**Application for Planning Permission and for relevant demolition of an unlisted building in a conservation area
Town and Country Planning Act 1990**

CHANGE OF USE FROM CHURCH TO 4NO. STUDIO FLATS AND WORKS TO REAR ELEVATION

Assuming no specific problems are brought to light we are optimistic that the application for the conversion of Seventh Day Adventist Church, 106 Sackville Street could be looked upon favourably.

ADVENTIST CHURCH - 106 SACKVILLE STREET

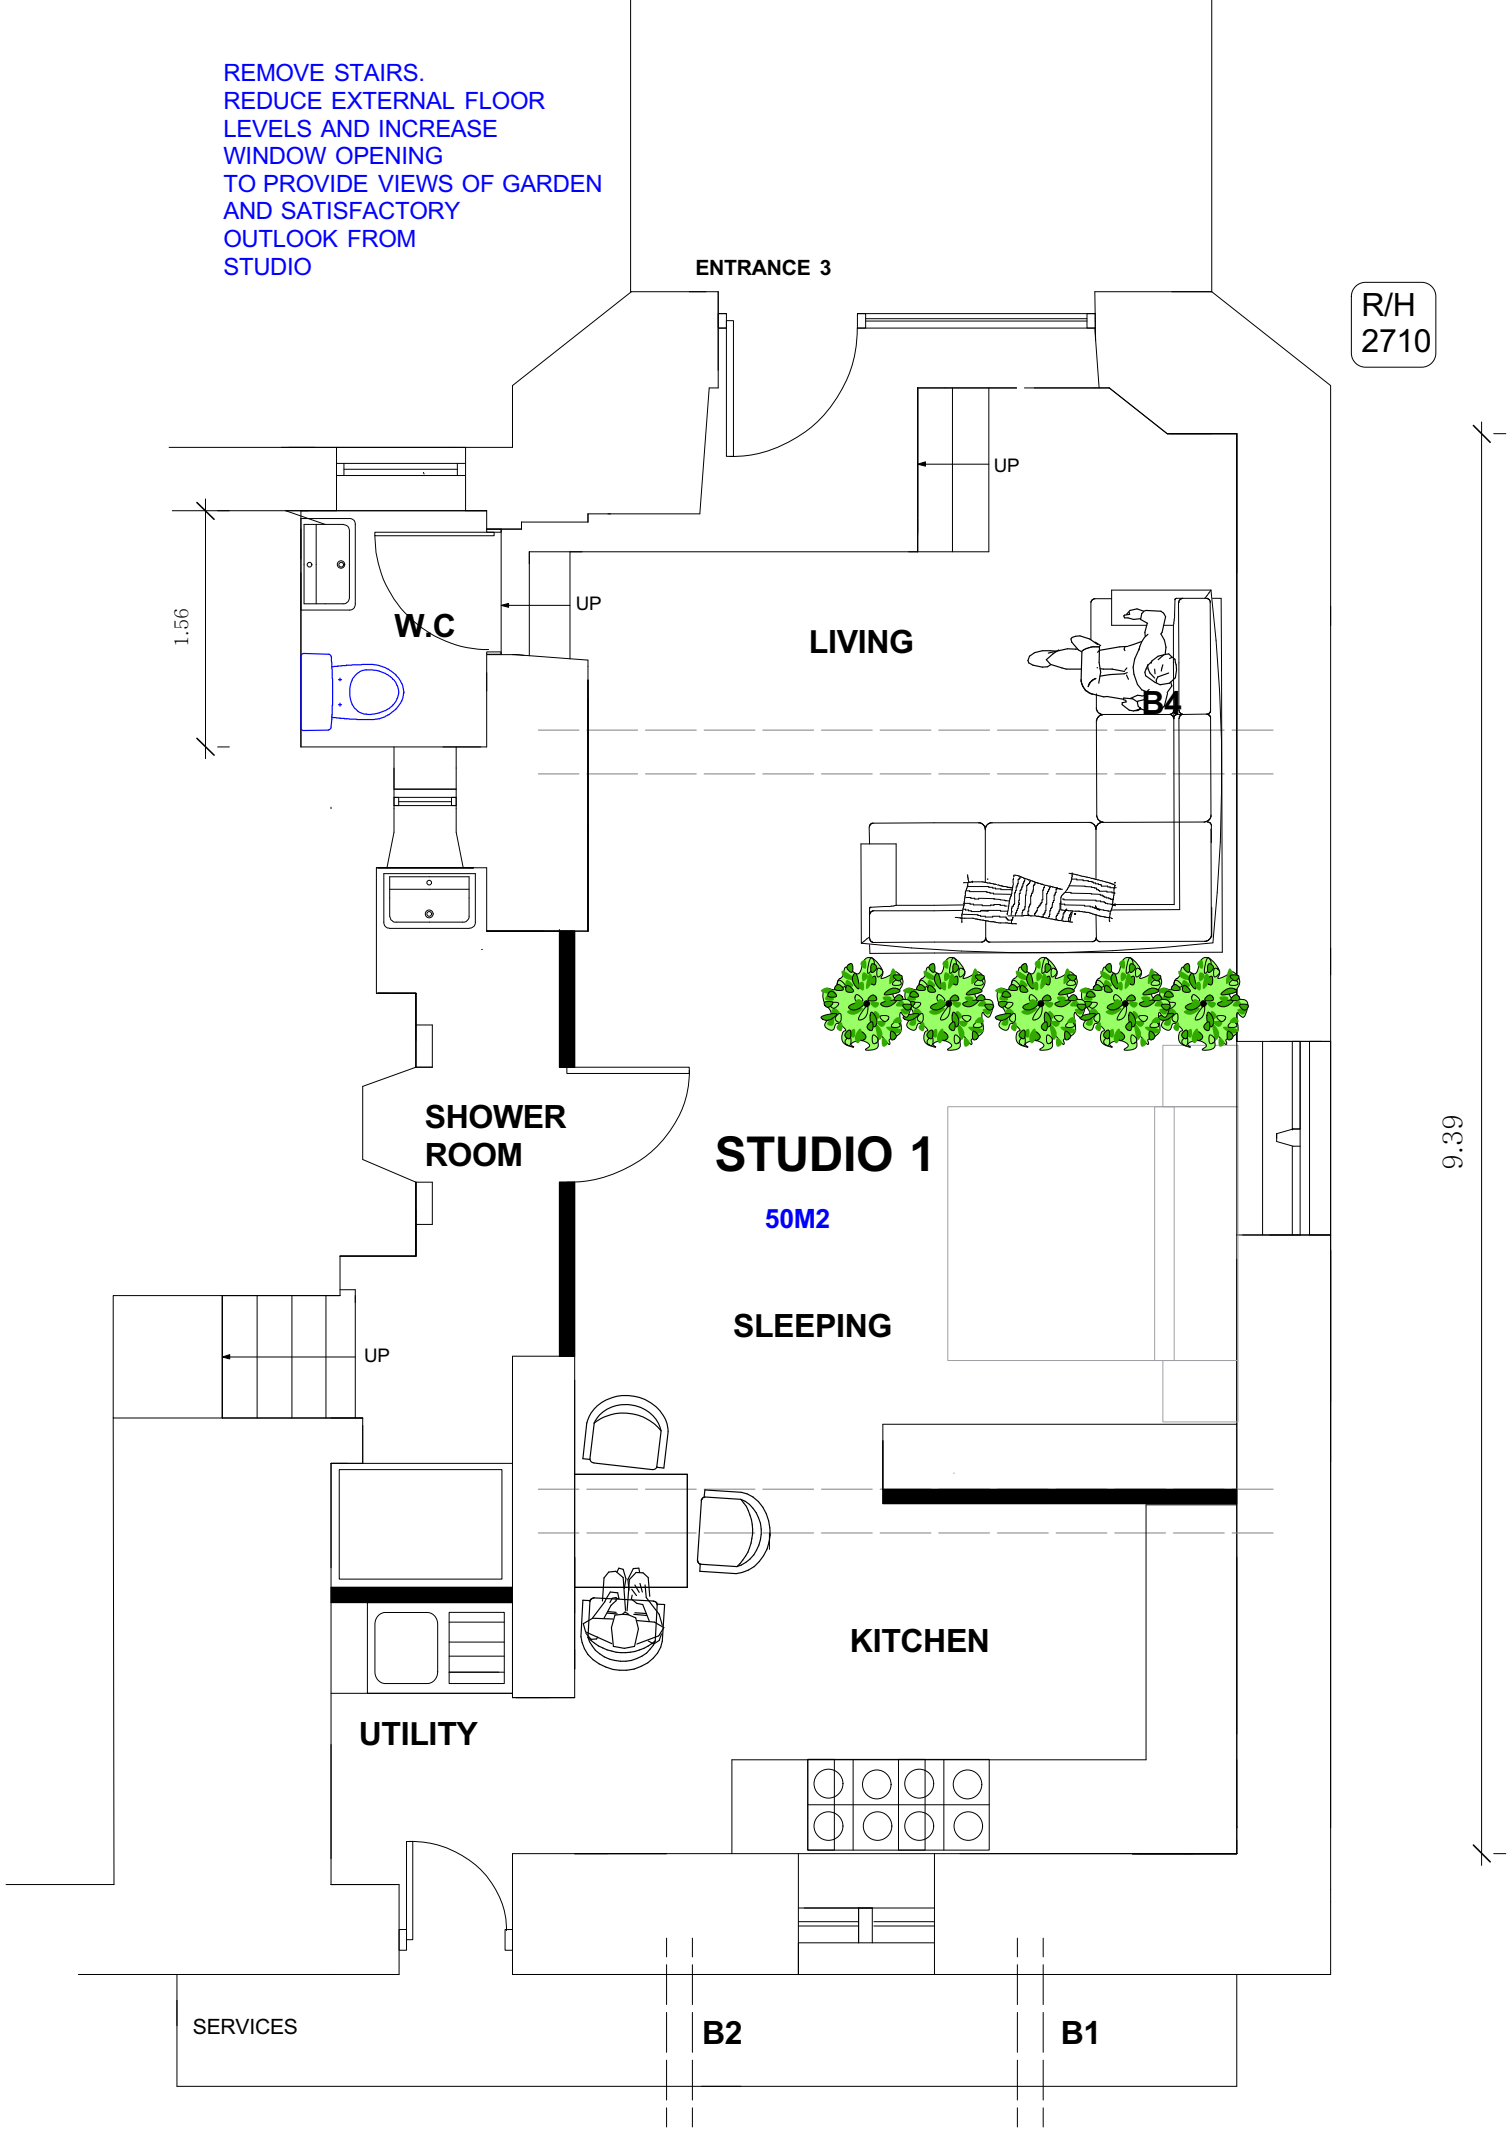
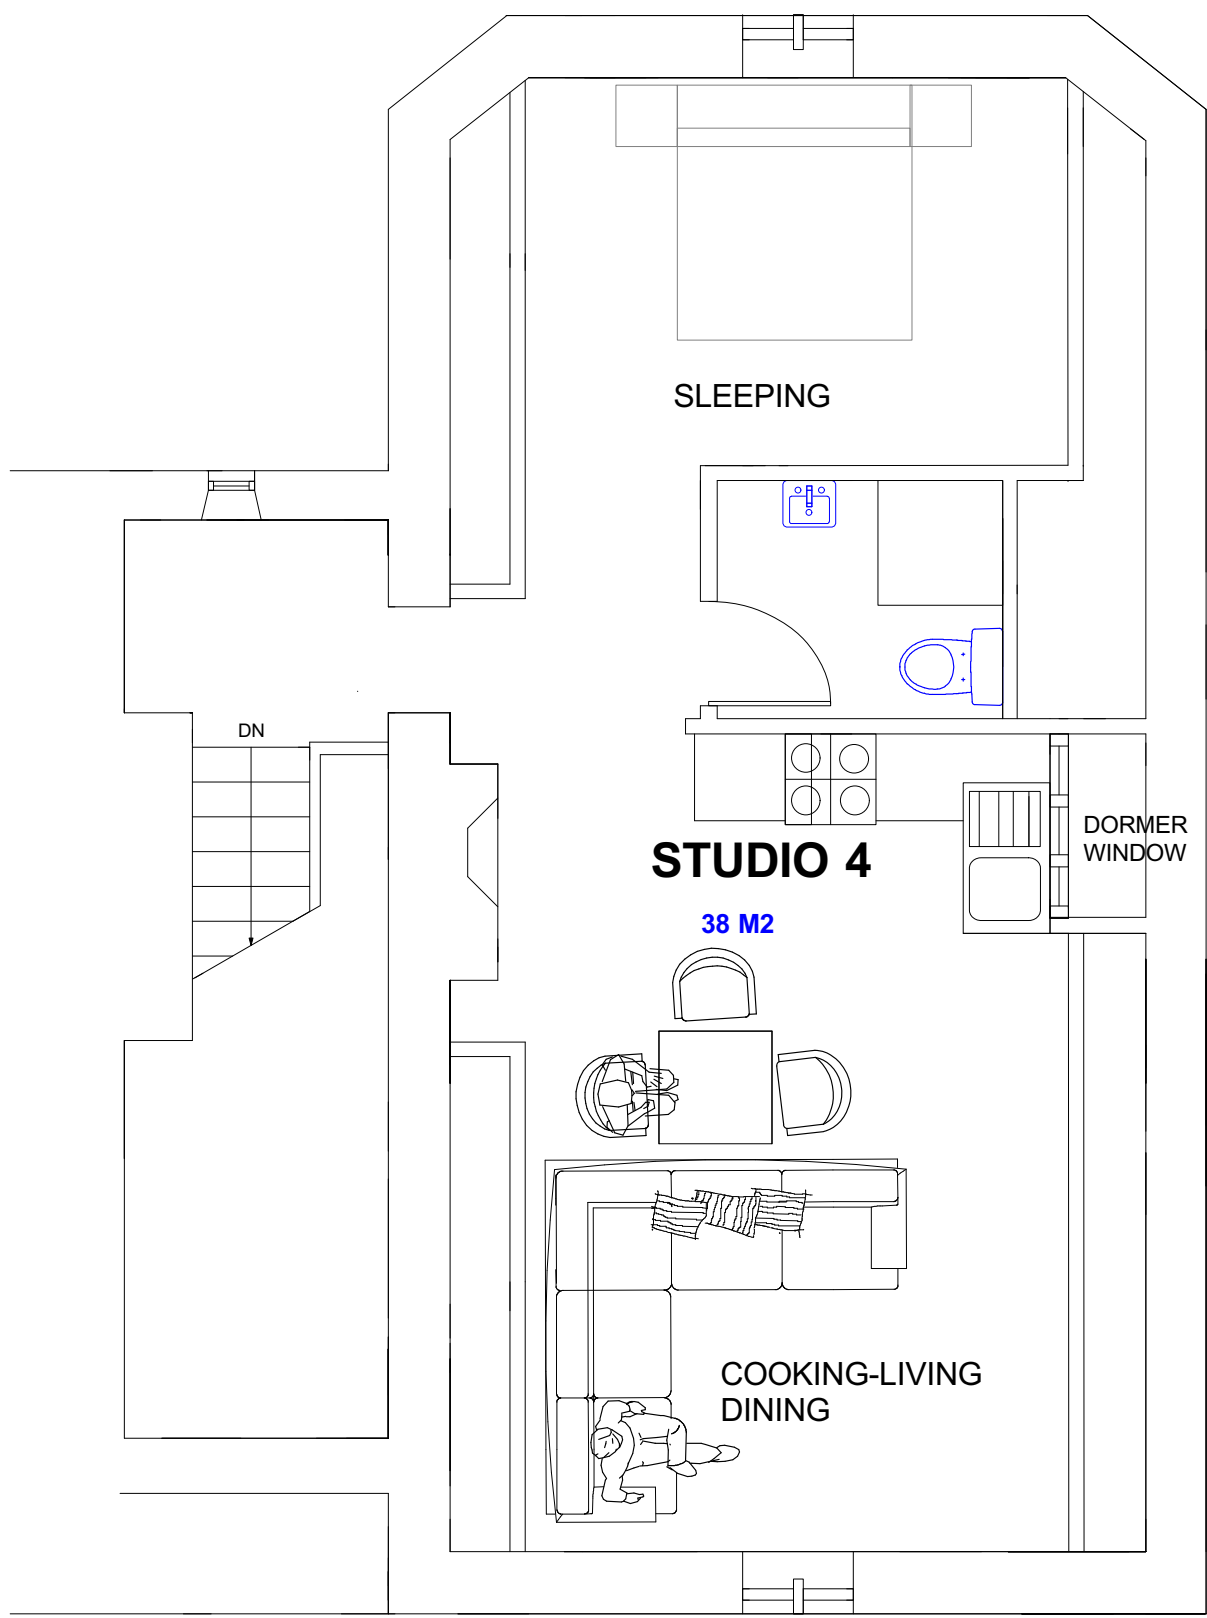
Whilst I believe that my concerns have been met in relation to the residential amenity issues regarding studio 1, by the removal of the external staircase and a reduction of the external floor levels in the garden. I would like to see some addition details, such as a cross section showing the cut away land.

The rear elevation window will be increased to achieve 1/10th of the floor area in accordance with the building regulations

The upper floors have been significantly redesigned

Ground floor - 51m2 one bedroom flat - meets SYRDG Standards of min. 46m2 for a one bedroom flat

Bedroom will be 12m2 minimum

First floor - 44m2 studio - meets SYRDG Standards of min. 33m2 for a studio
